Recommendation Report for Planning Permission for Works or Extension to a Dwelling

REF NO: FG/135/18/HH

LOCATION: 14 Sark Gardens
Ferring
BN12 5QB

PROPOSAL: Single storey side & rear extensions, conversion of garage to habitable accommodation with new roof over & insertion of roof window & sun pipes.

DRAWING TITLE
**Proposed Plans
Scheme 3**

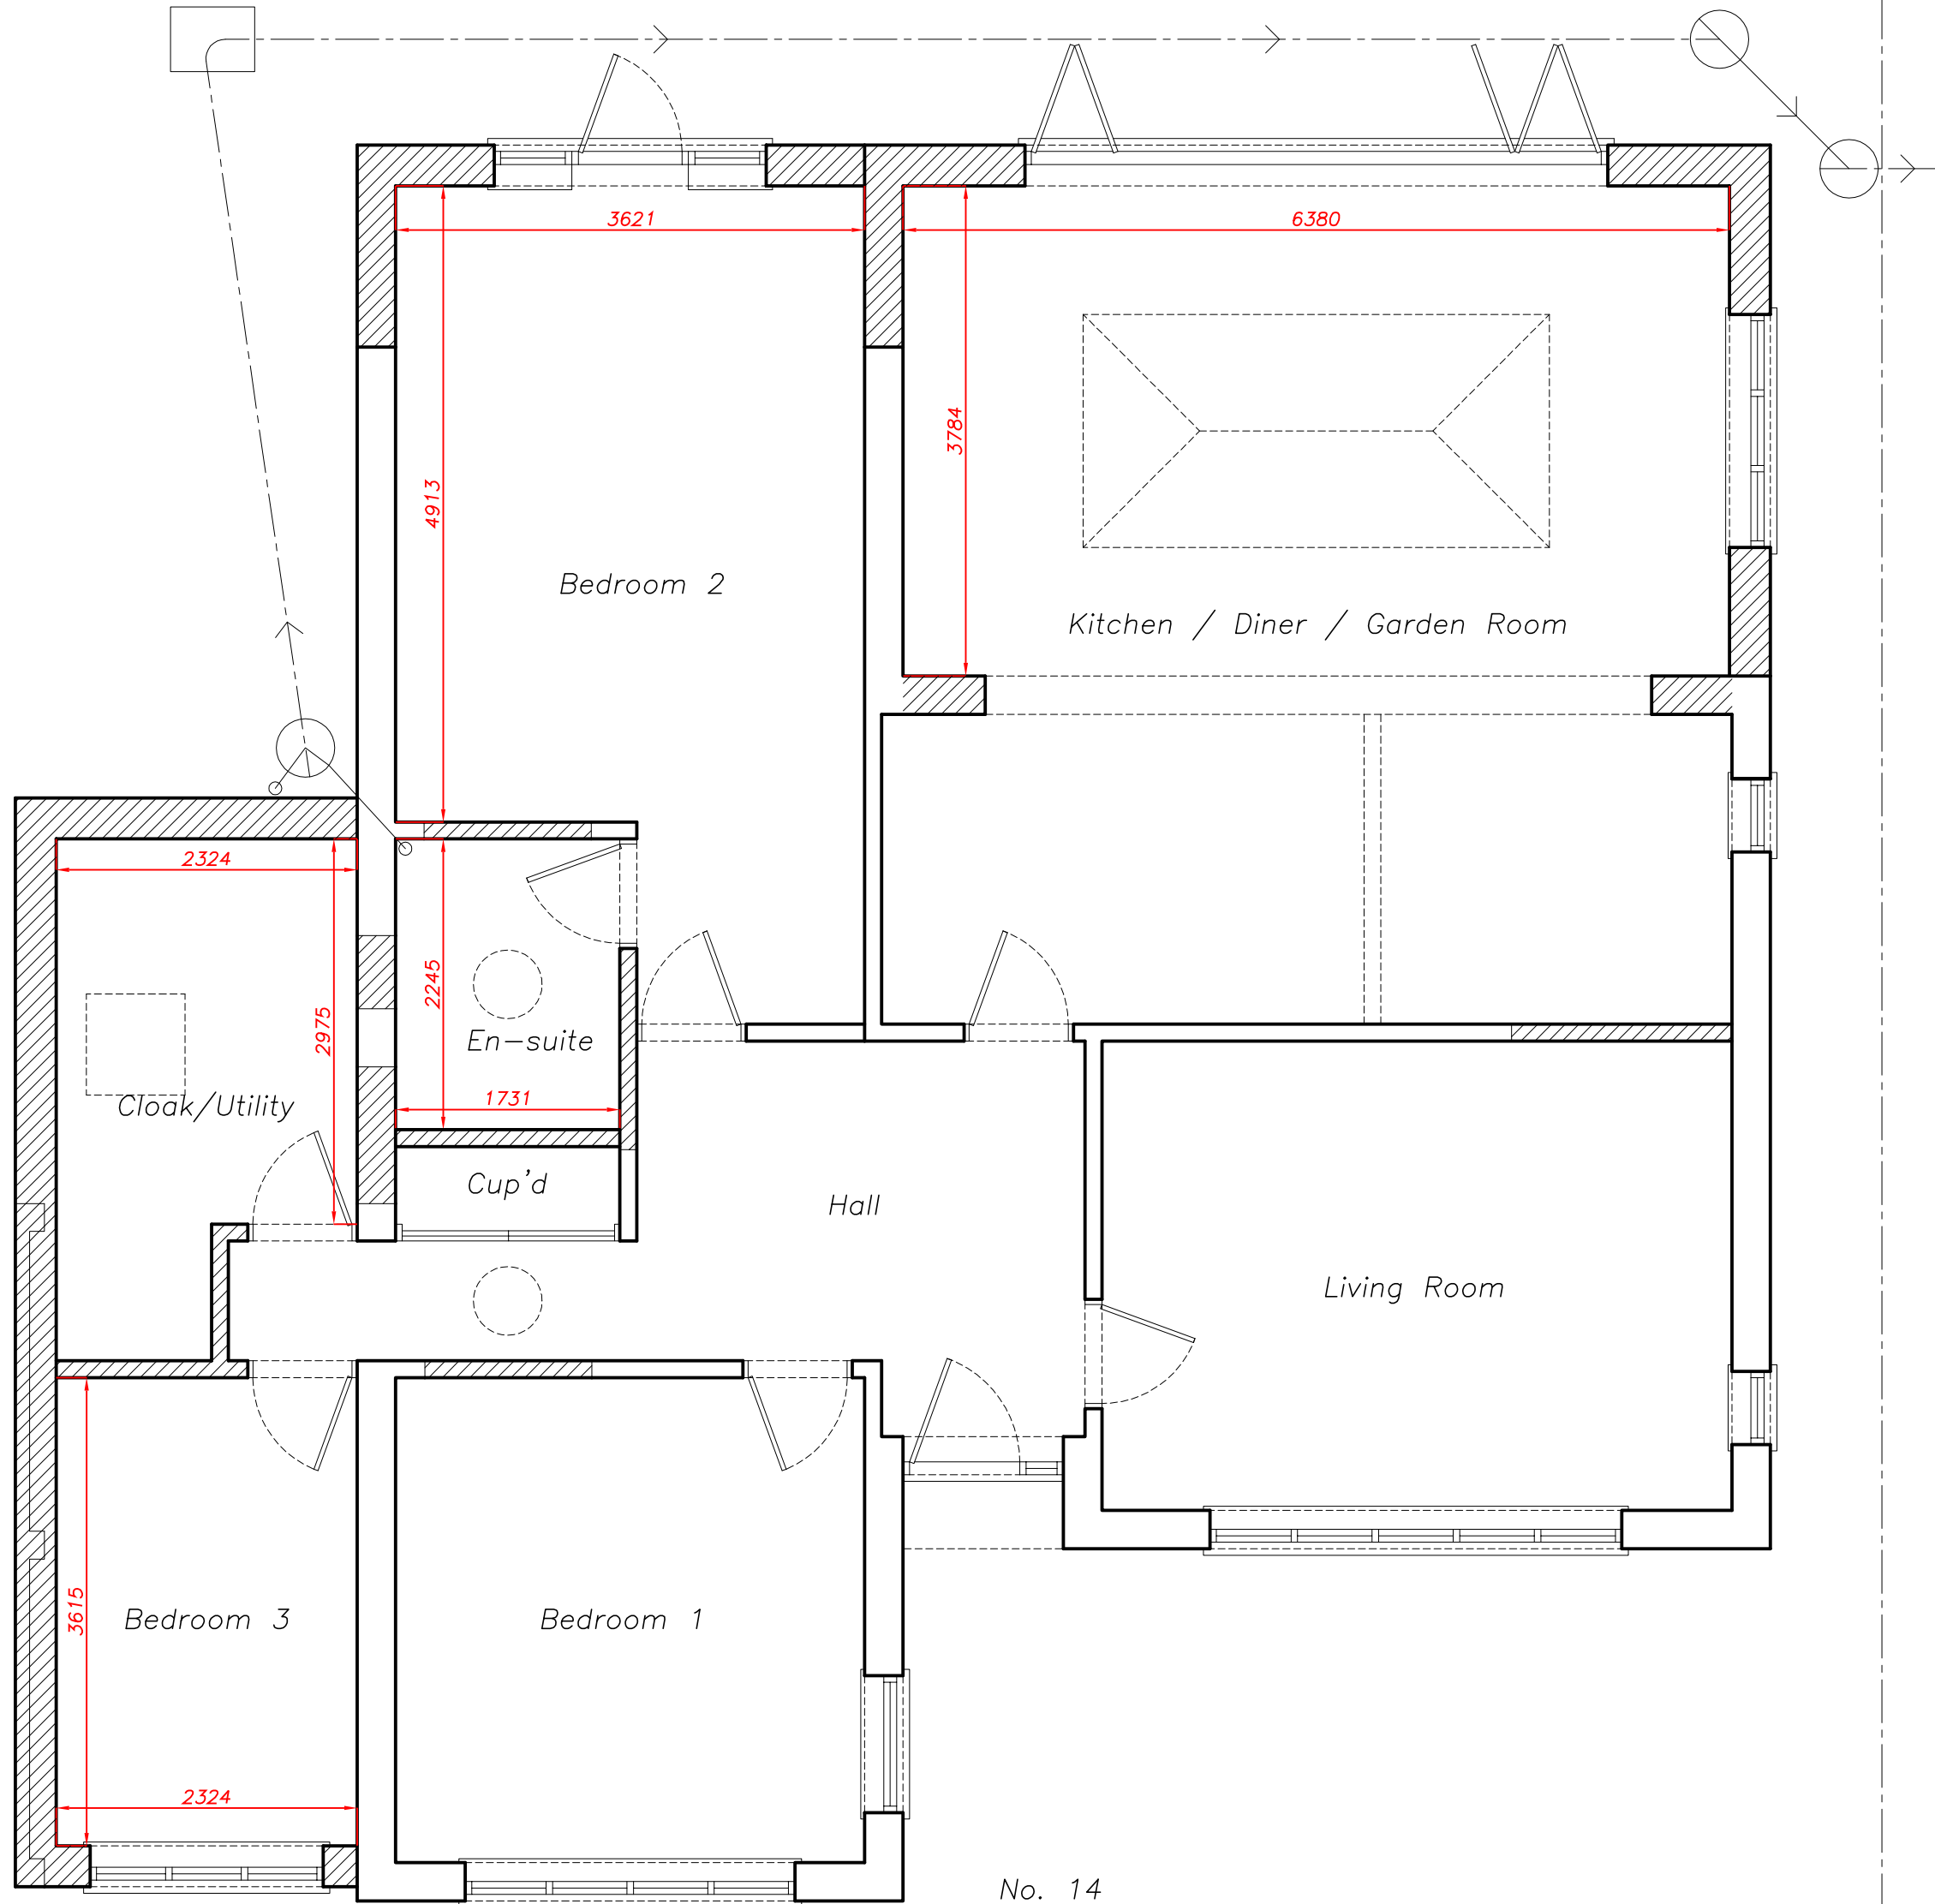
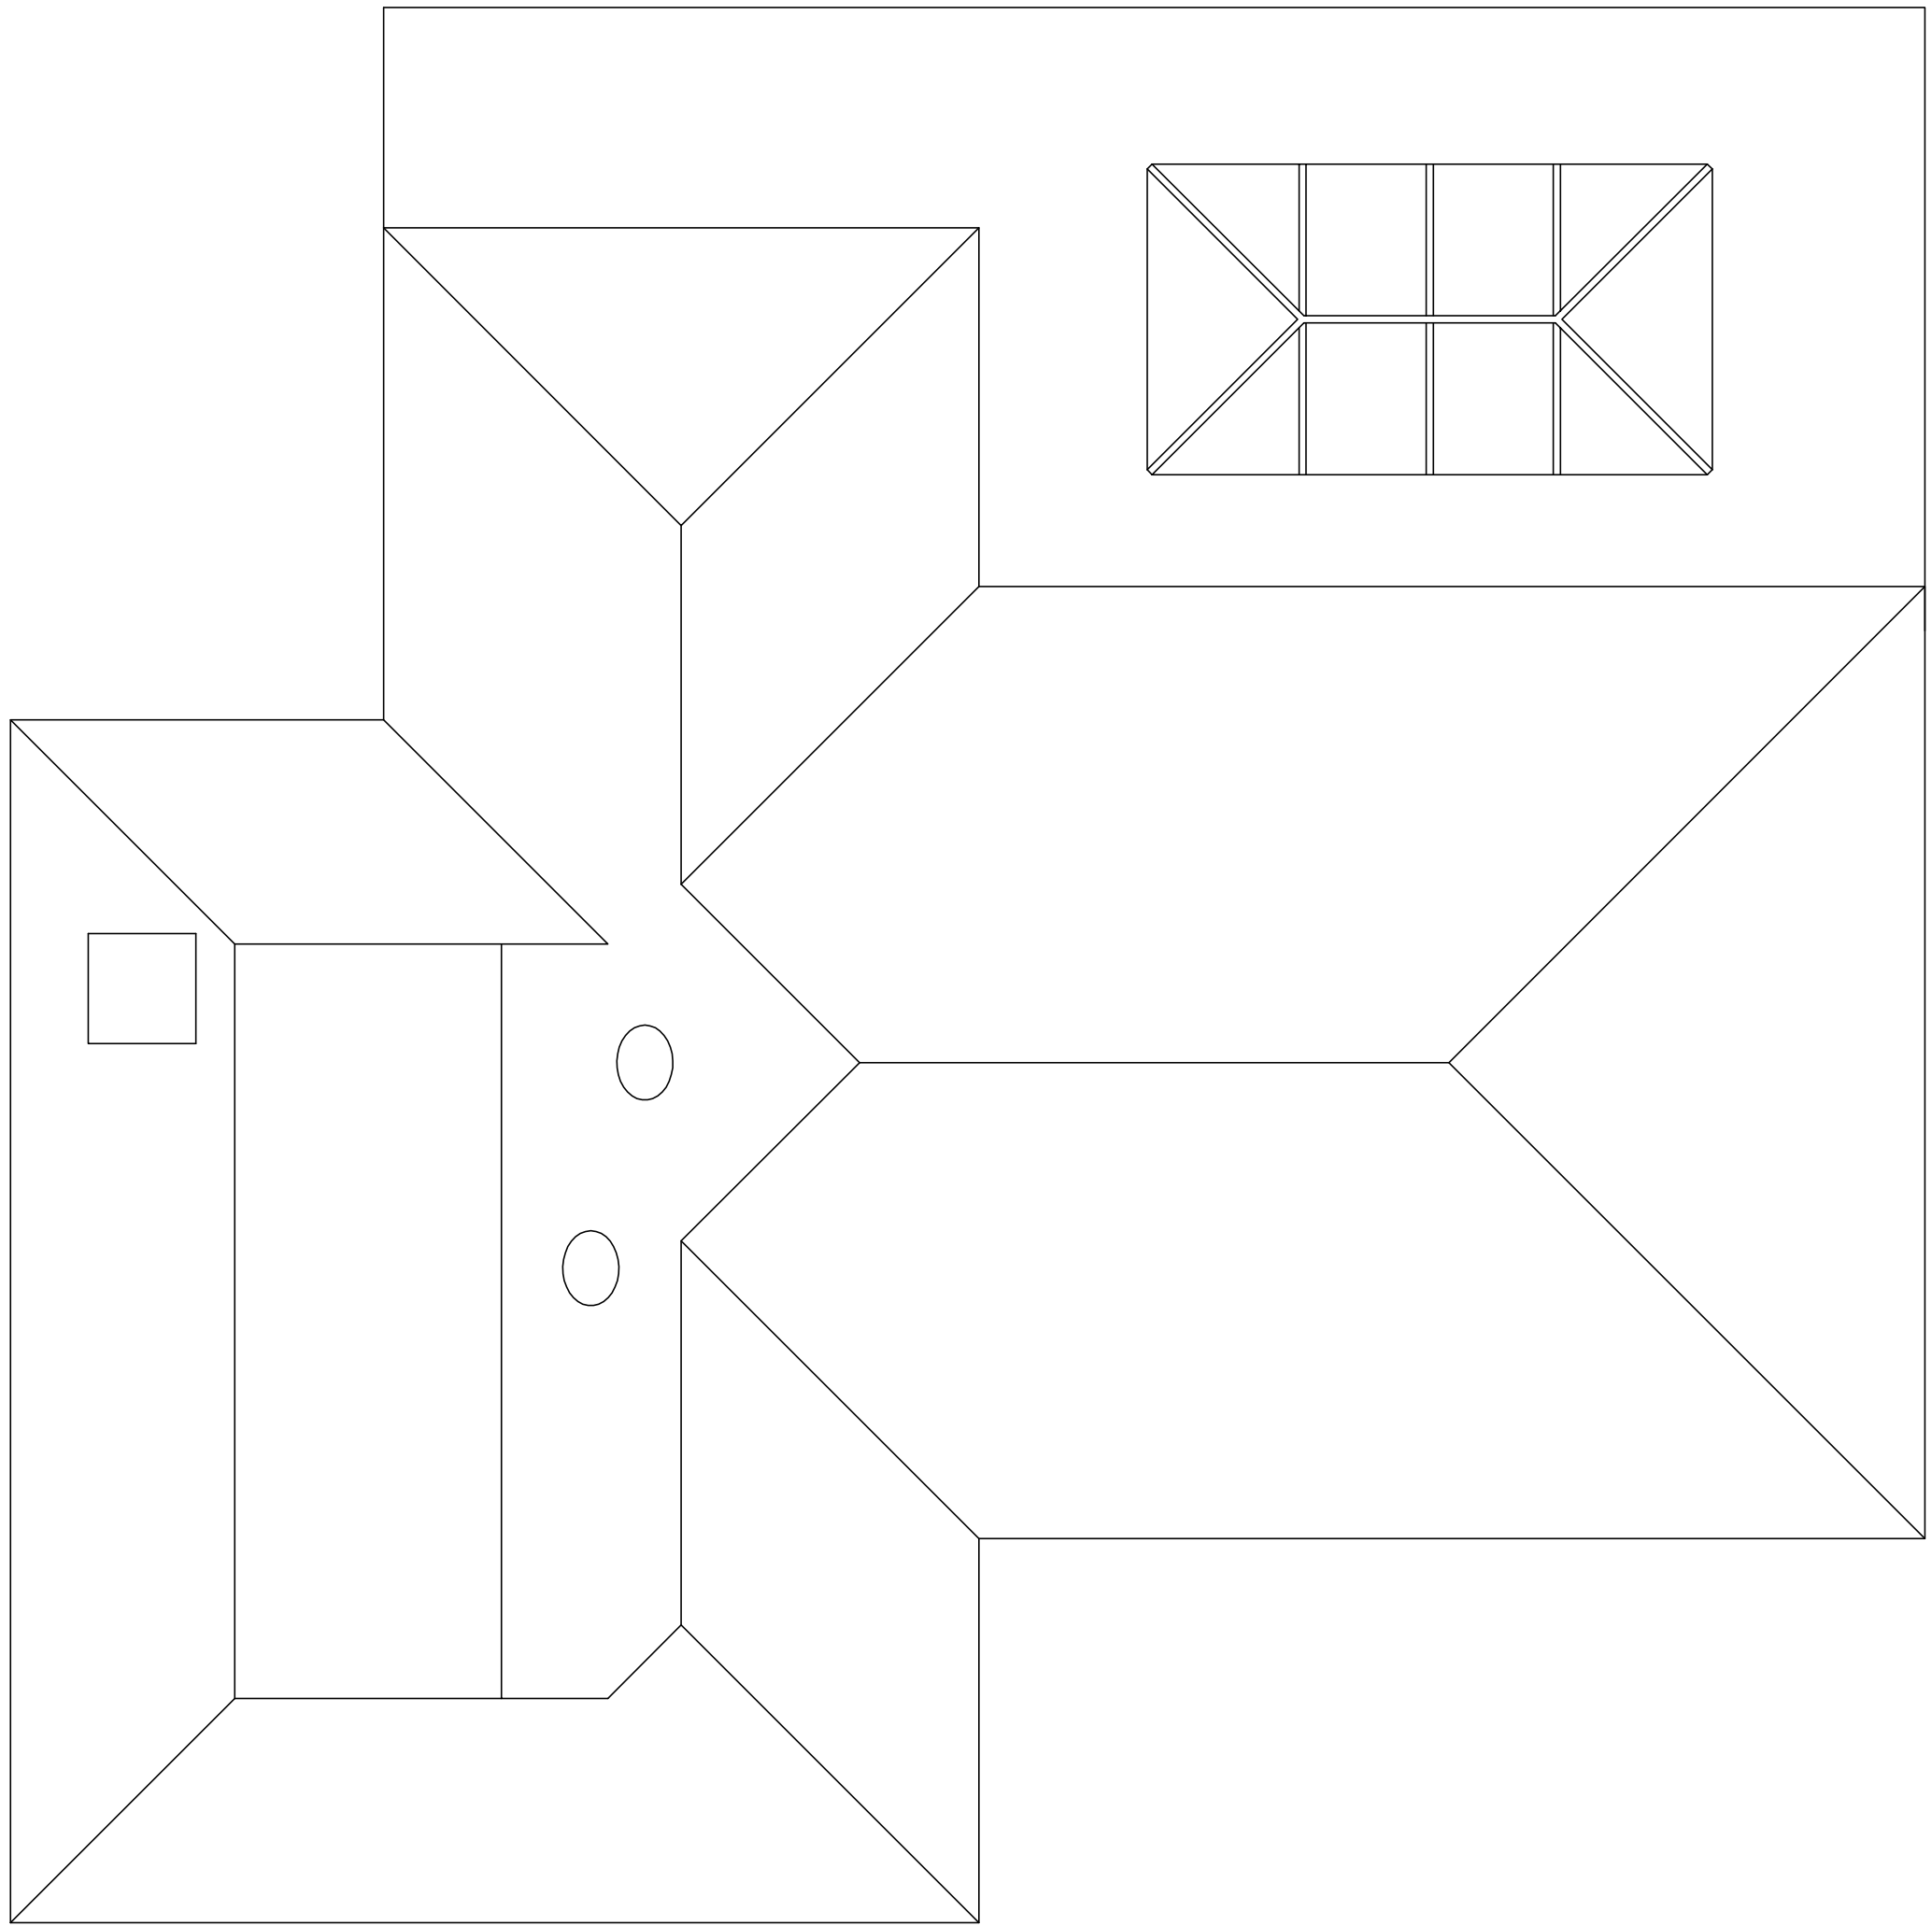
The development proposes a side and rear extension. The side extension will be situated to the rear of the existing garage and will extend a further 3m to the north although the width will remain as existing. Due to the location of the side extension and the boundary treatments, it is not considered to give rise to any impacts upon the neighbouring amenity.

Doors to the rear of the existing garage will be removed and 2 sets of bi fold doors will be installed to the rear extension with one set replacing an existing window. There is 1 window proposed to the east elevation however due to the boundary treatment it is not considered to give rise to any harmful overlooking impacts. At the western elevation, a velux window is also proposed to the extended garage, however again due to the sufficient boundary treatment and location of the neighbouring dwelling, the window is not deemed to give rise to any overlooking.
